From: Simon Davis
Sent: 06 December 2018 09:20
To: Planning.Responses
Subject: FW: P/107/18/DOC 7 Webb Close

Further Drainage comments

From: Laura Gibbons
Sent: 06 December 2018 09:18
To: Simon Davis
Subject: RE: P/107/18/DOC 7 Webb Close

BEDDING FOR OTHER FLEXIBLE PIPES

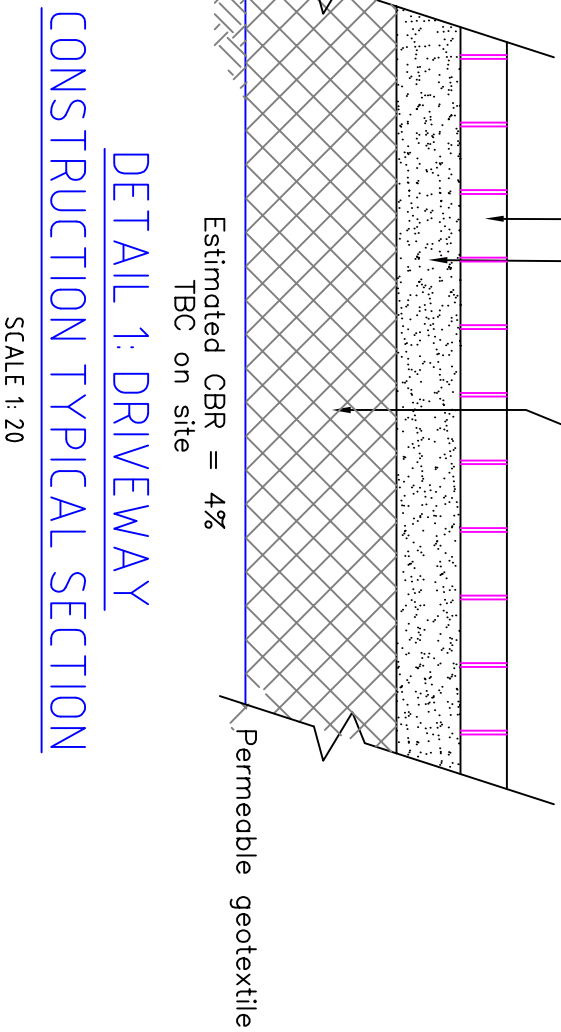
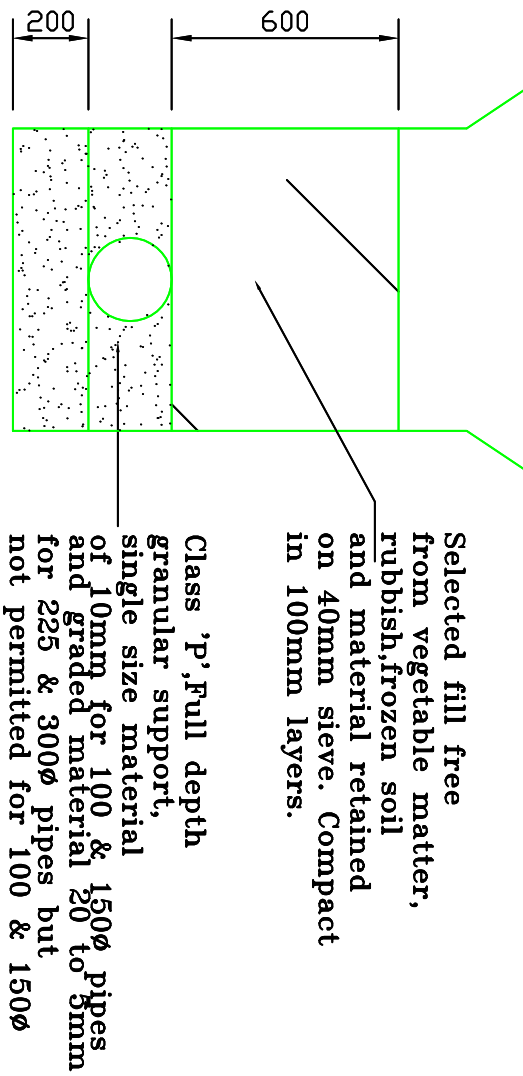
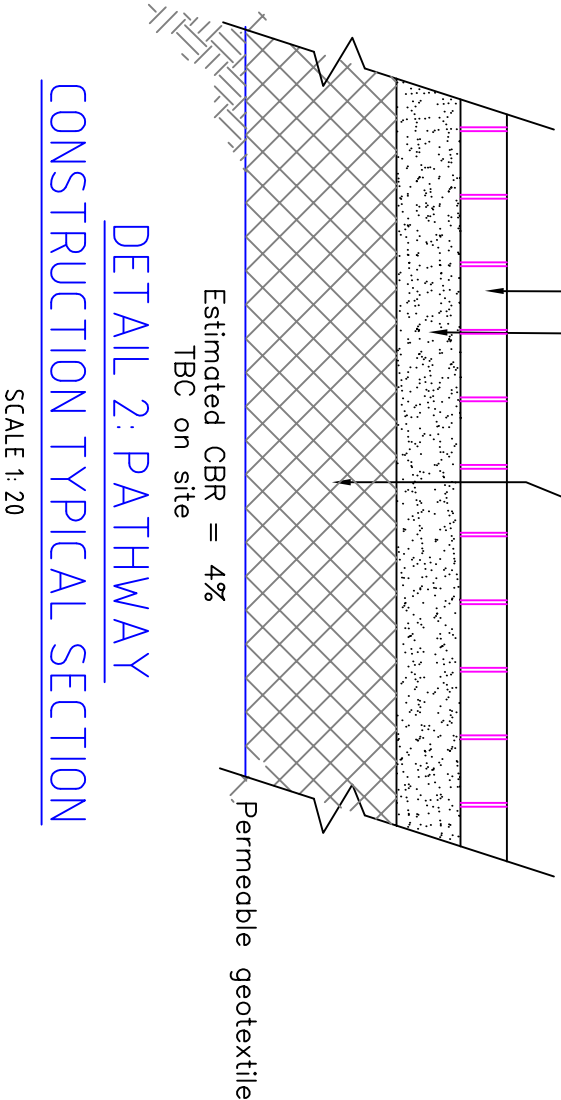
The soakaway details are fine. Can the permeable paving and driveway details be updated to include a permeable geotextile fully wrapping around the sub base, not just under it. And the pipe details for pipes 900-1200mm deep under roads and bedding for other flexible pipes need to both be updated to include a minimum of 150mm granular bed and surround (including the top). I apologise that I did not pick up on this before.
